## PLAN SNAPSHOT REPORT SP-2025-00066 FOR CITY OF ALBUQUERQUE

<b>Plan Type:</b> Site Plan	<b>Project:</b> PR-2021-005714 (PR-2021-005714)	<b>App Date:</b> 08/29/2025
<b>Work Class:</b> EPC	<b>District:</b> City of Albuquerque	<b>Exp Date:</b> 08/28/2028
<b>Status:</b> Fees Due	<b>Square Feet:</b> 0.00	<b>Completed:</b> 09/08/2025
<b>Valuation:</b> \$0.00	<b>Assigned To:</b>	<b>Approval Expire Date:</b> 09/06/2032
<b>Description:</b> Discount Towing Facility - Submission to the EPC for site plan approval		
Parcel: 101406050923542201 Main	Address: 4000 2Nd St Nw 4000 2Nd St Nw Albuquerque, NM 4000 2Nd St Nw Albuquerque, NM 87107	Zone:

A1.1
TCL

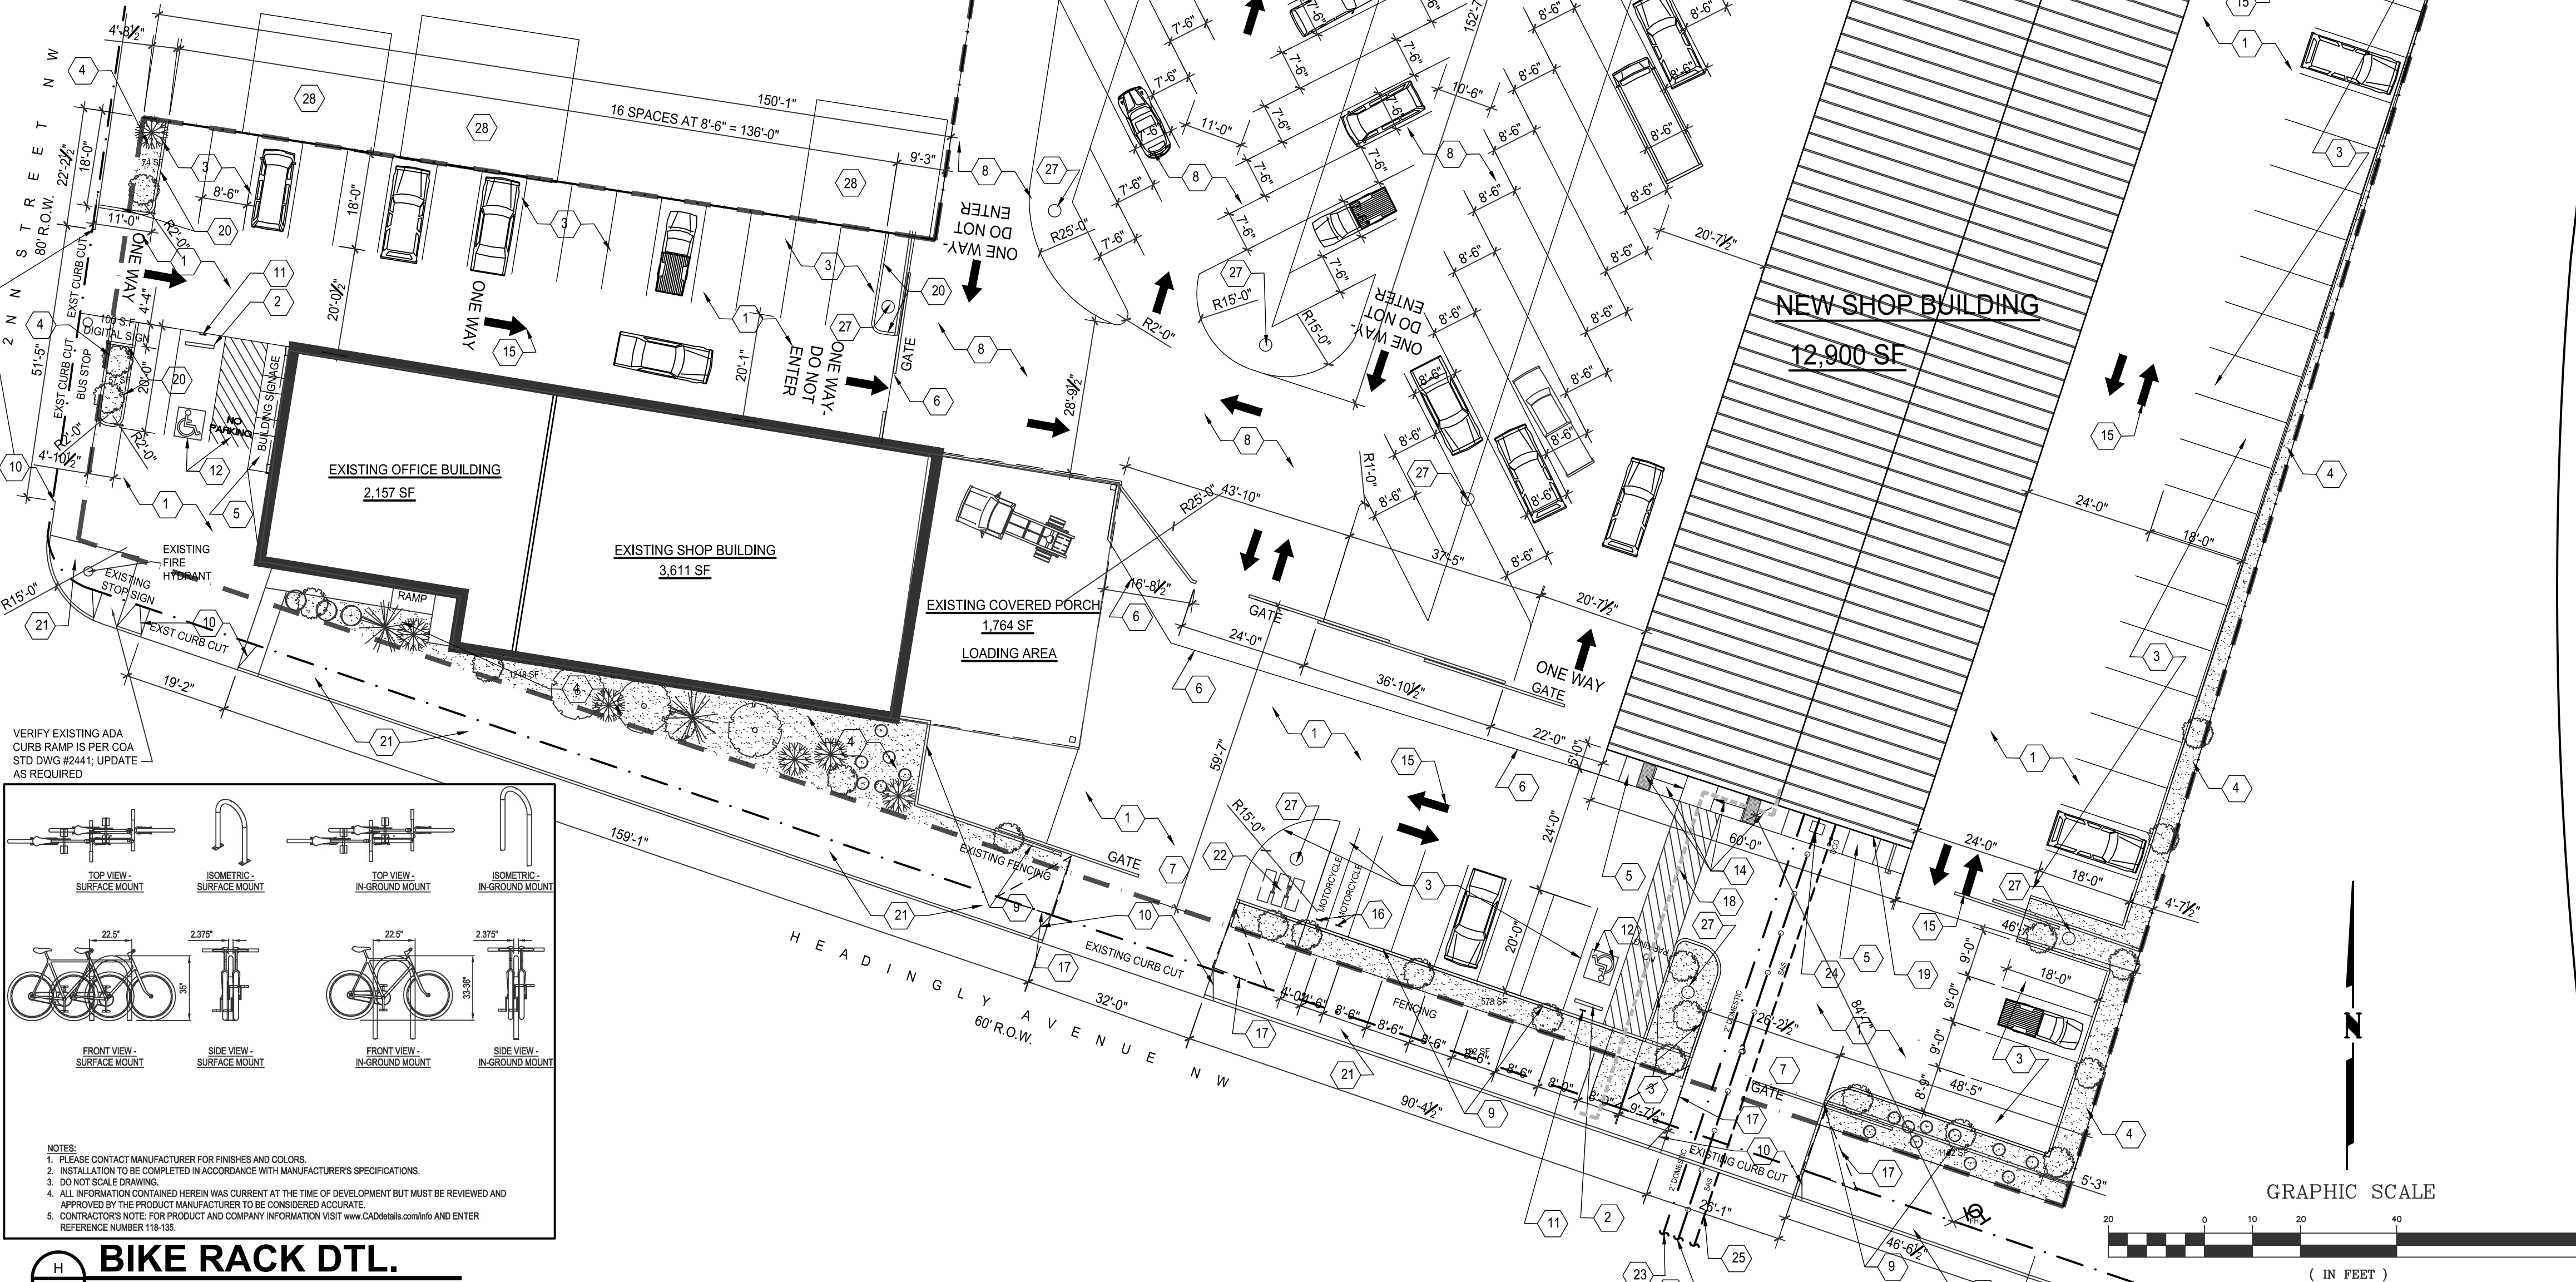
NO BUILDING INFORMATION. PLEASE INCLUDE: CONSTRUCTION TYPE.

FIRE SPRINKLER INFORMATION. FIRE ACCESS ROAD INFORMATION AND ENGINEERING INFORMATION, INCLUDING WEIGHT OF LOAD. TURNOUT MUST BE A MINIMUM OF 28 FEET. MAKE SURE THIS IS IN PLACE FOR ALL PARTS OF ACCESS ROADS. KNOX BOX LOCATION. HYDRANT LOCATION REFER TO THE FIRE 1 CHECKLIST FOR FURTHER REQUIREMENTS AND DETAILS.

LANDSCAPING PLAN

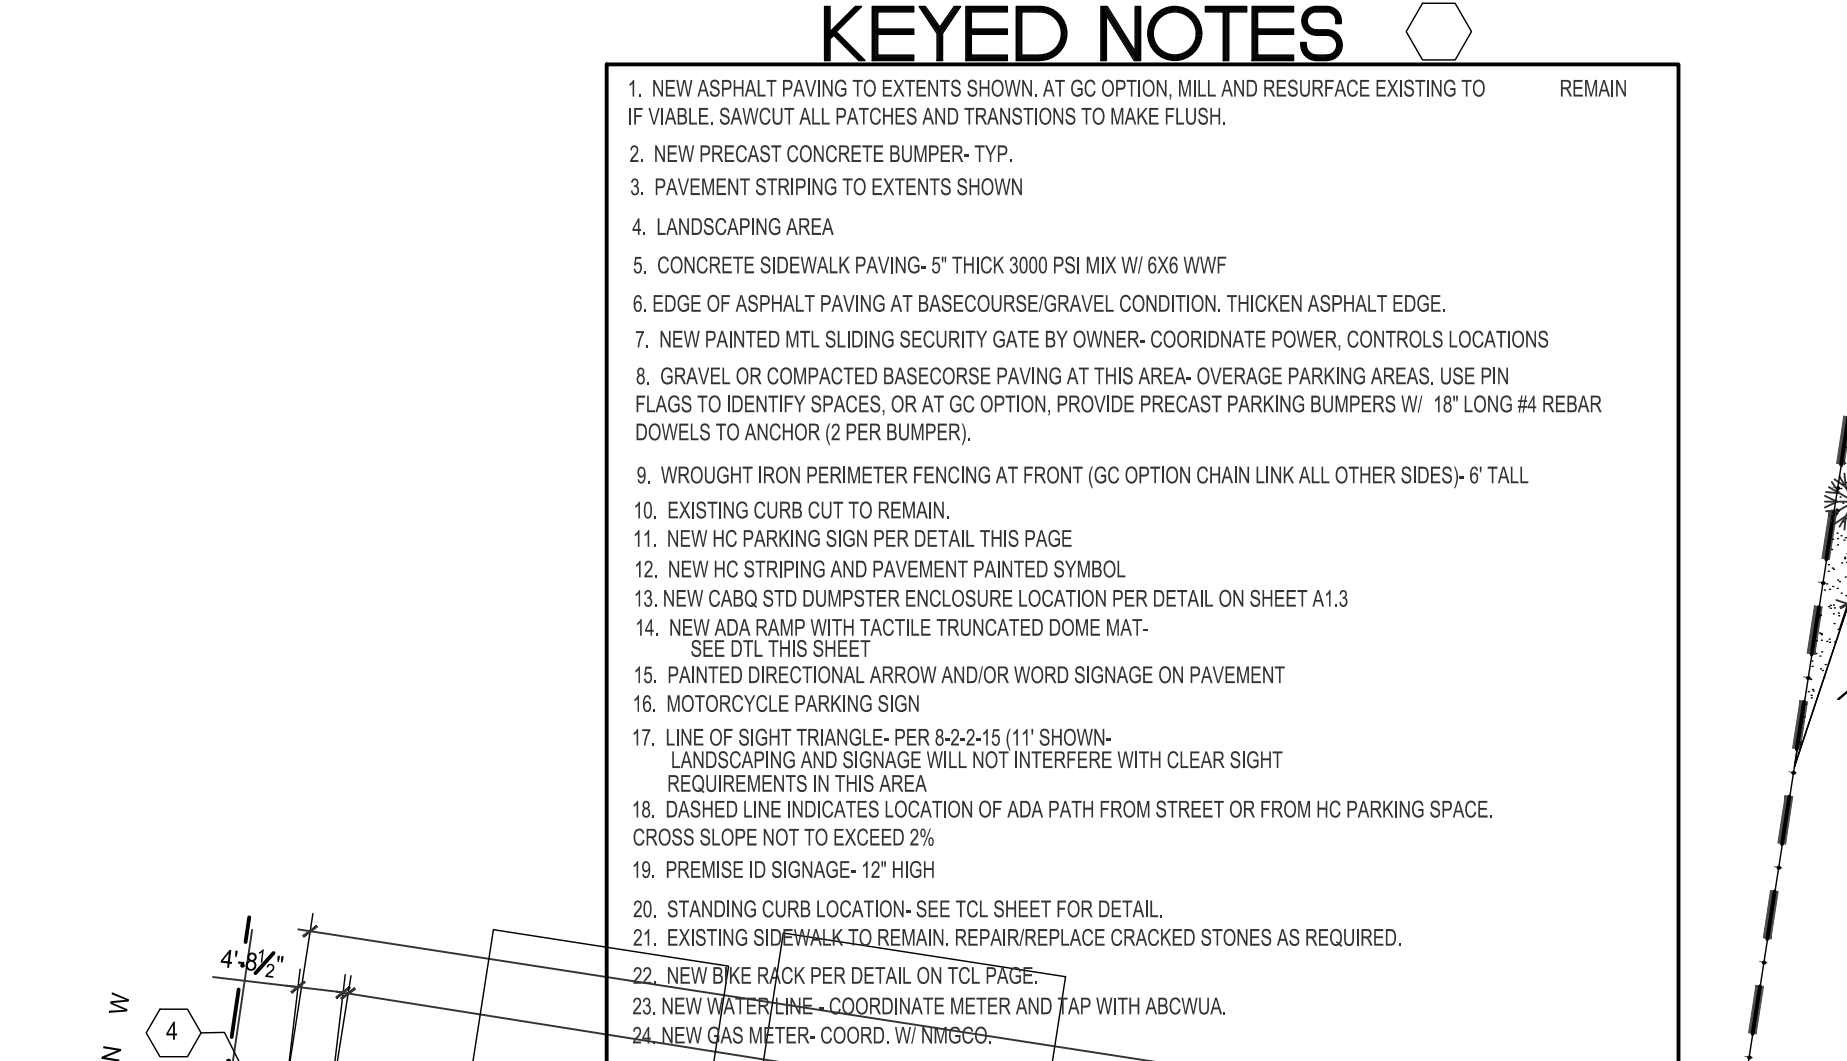
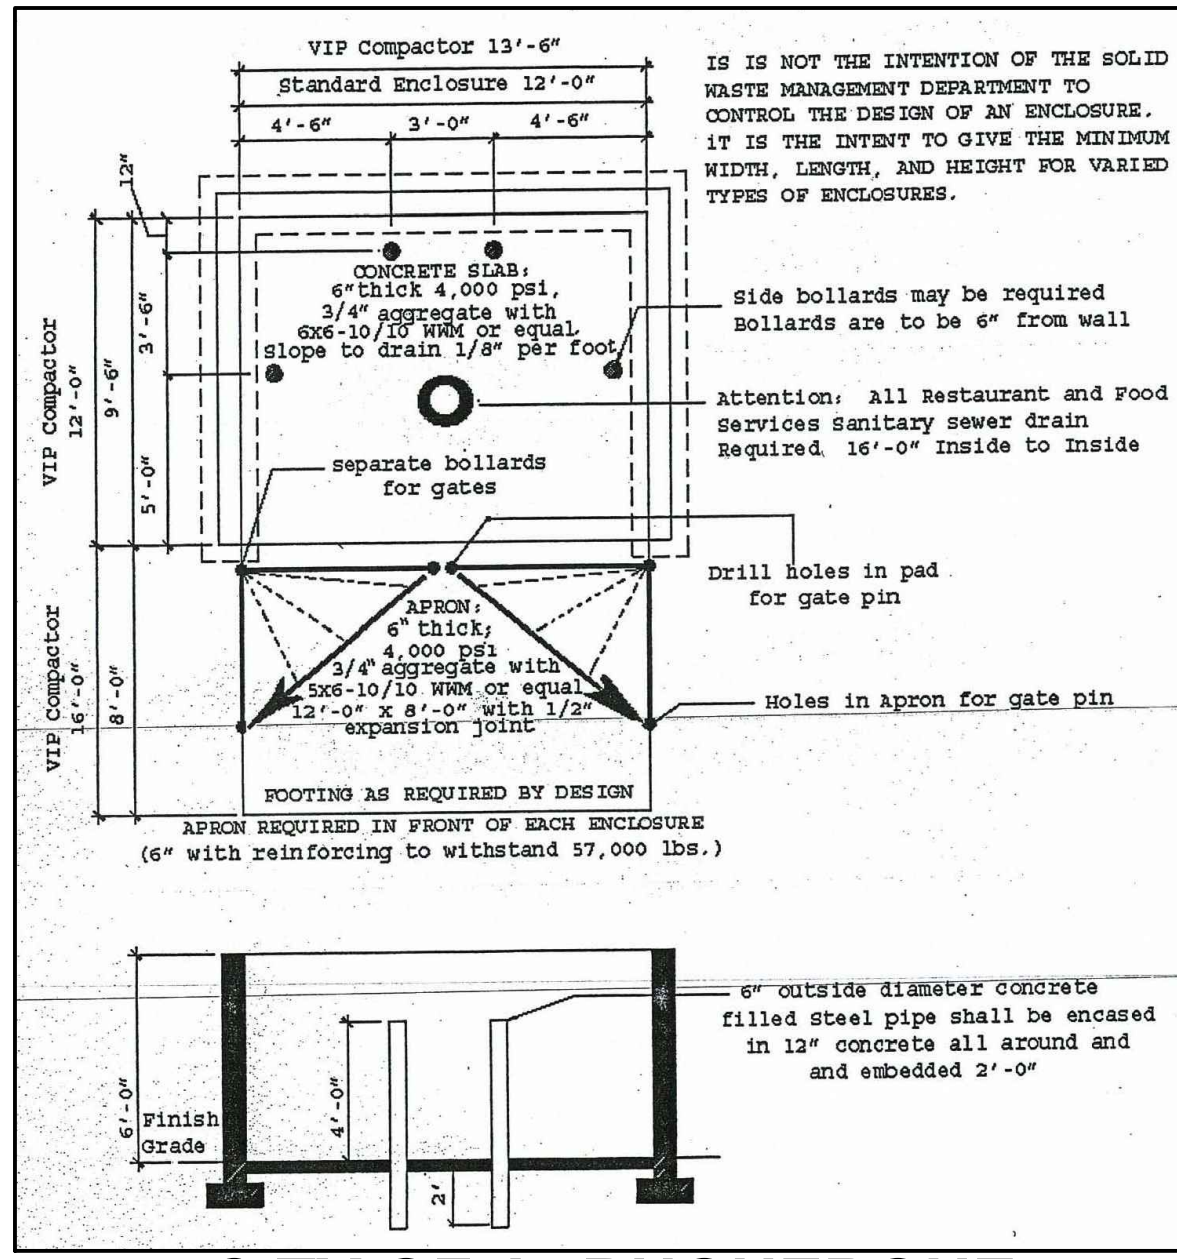
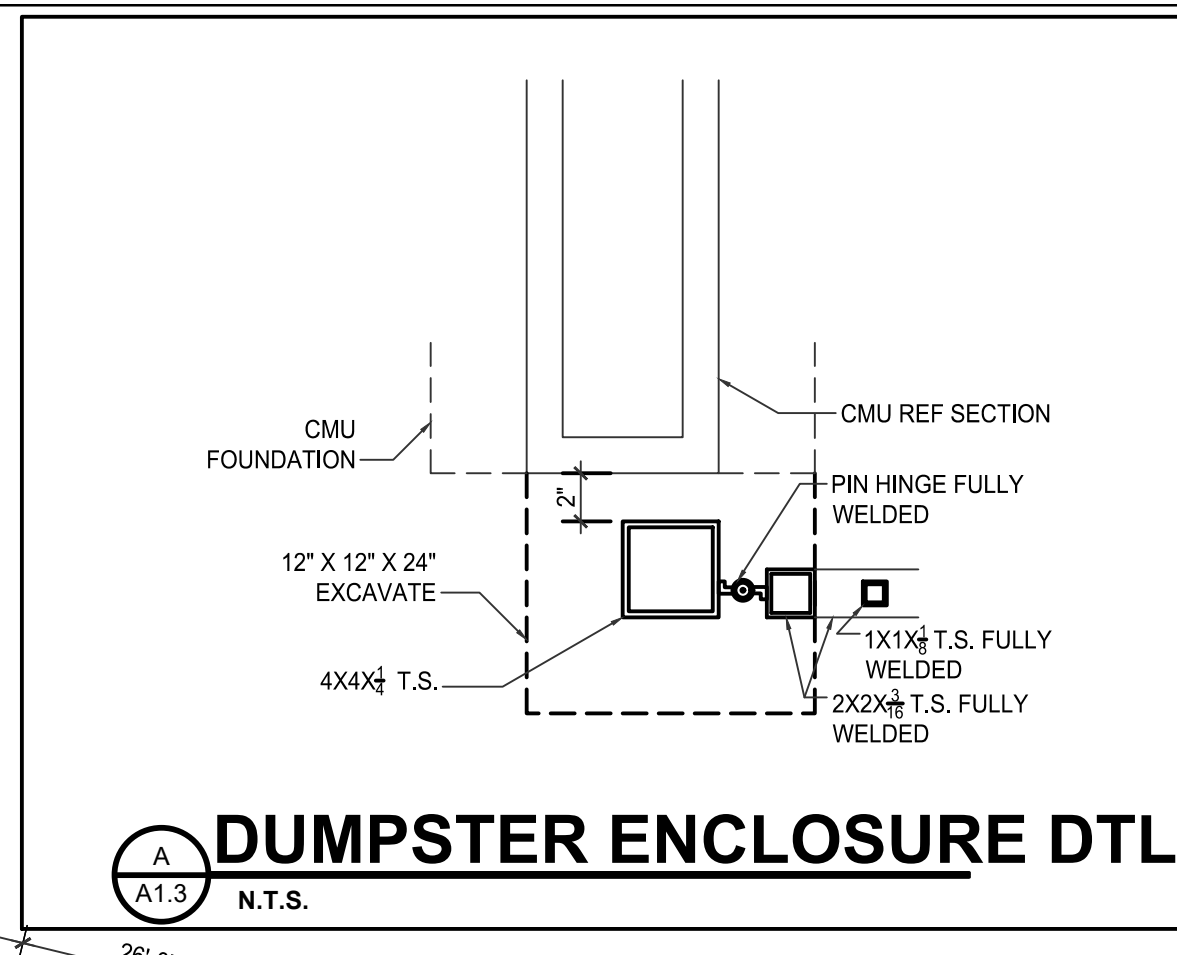
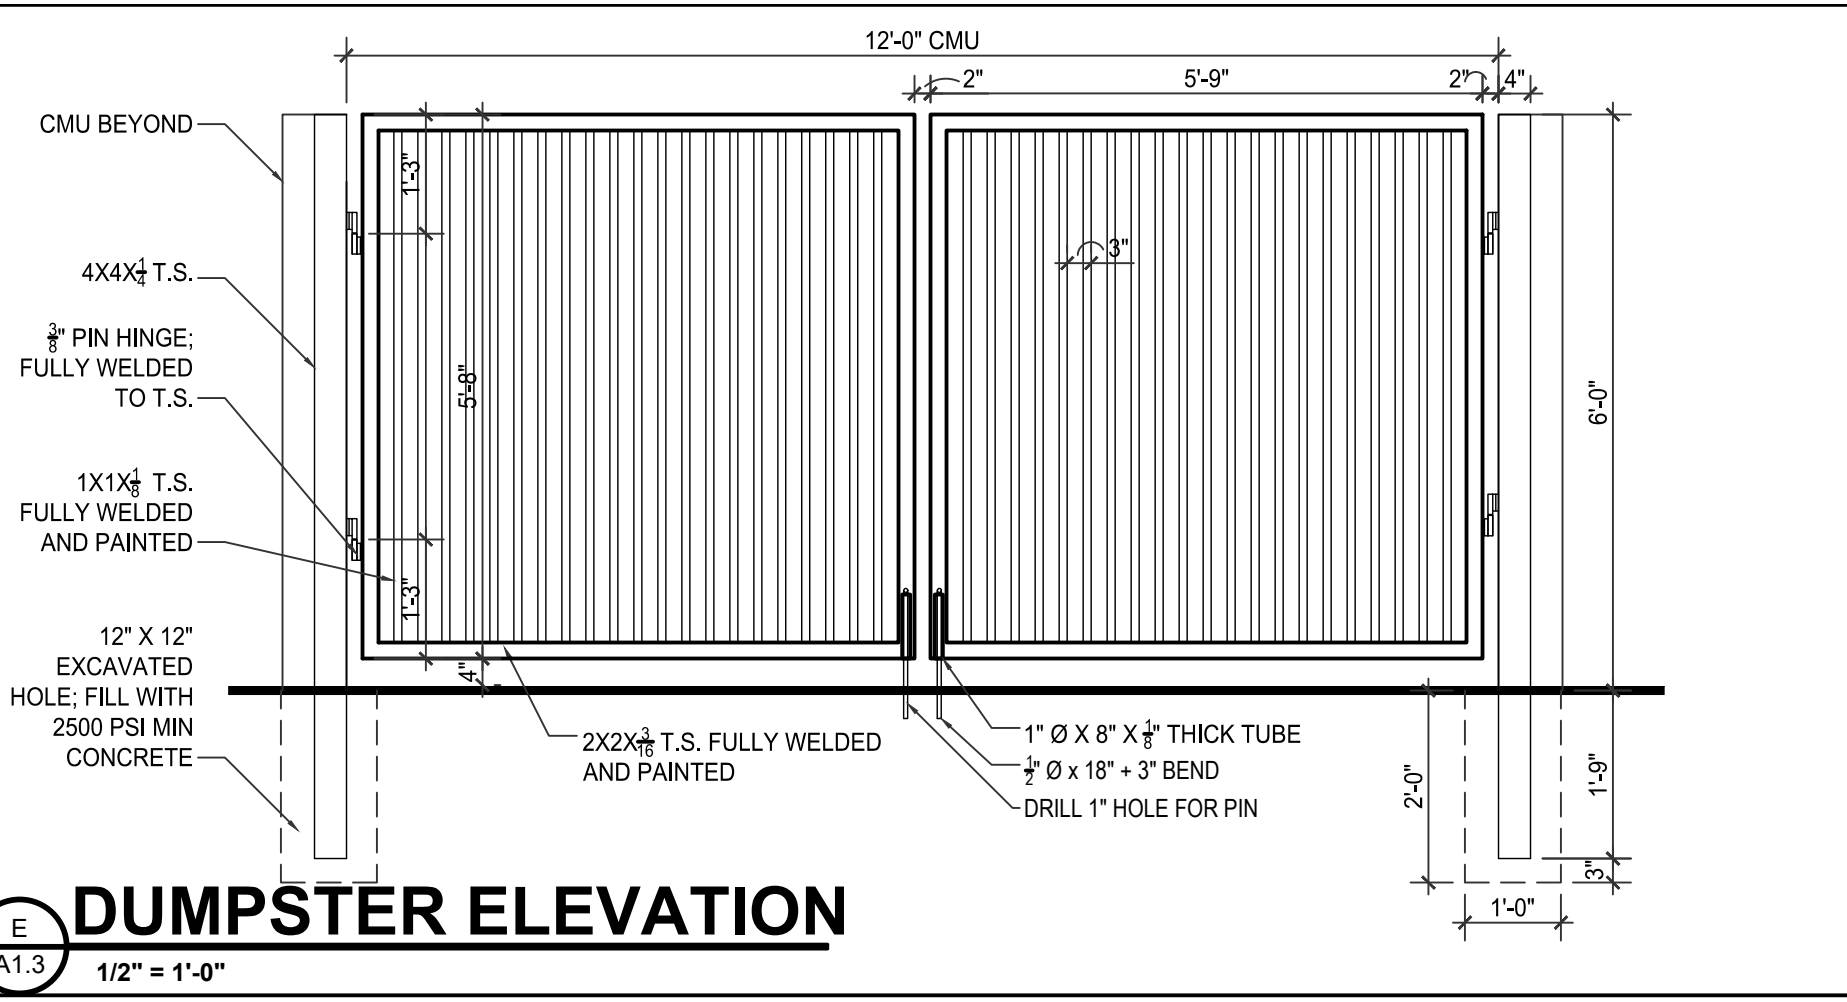
Item Review Name	Department	Assigned User	Status	Assigned Date	Due Date	Completed Date
Zoning	Zoning	Palmer, Jeff	Comments Given/No Comments	09/09/2025	09/29/2025	09/11/2025
<b>Comments:</b> Landscaping -- A minimum of 10 species must be used in the landscaped area. IDO 5-6(C4)(a). Building Design - Need to incorporate design feature(s) on street-facing facade as required per IDO 5-11(G). JPalmer, CE Supervisor						
Workflow Step / Action Name			Action Type	Start Date	End Date	
<b>Linked Project Plans v.1</b>				09/02/2025	12:18	
Linked Plan Applications v.1				Create Plan Case	09/02/2025	12:18
<b>Application Intake v.1</b>				09/02/2025	12:18	
Associate Project Number v.1				Generic Action	09/02/2025	12:18
Screen for Completeness v.1				Generic Action	09/04/2025	11:27
Sign Posting v.1				Generic Action	09/08/2025	13:57
Verify Payment v.1				Generic Action	09/08/2025	13:57
<b>Application Review v.1</b>				09/08/2025	13:57	10/17/2025 15:05
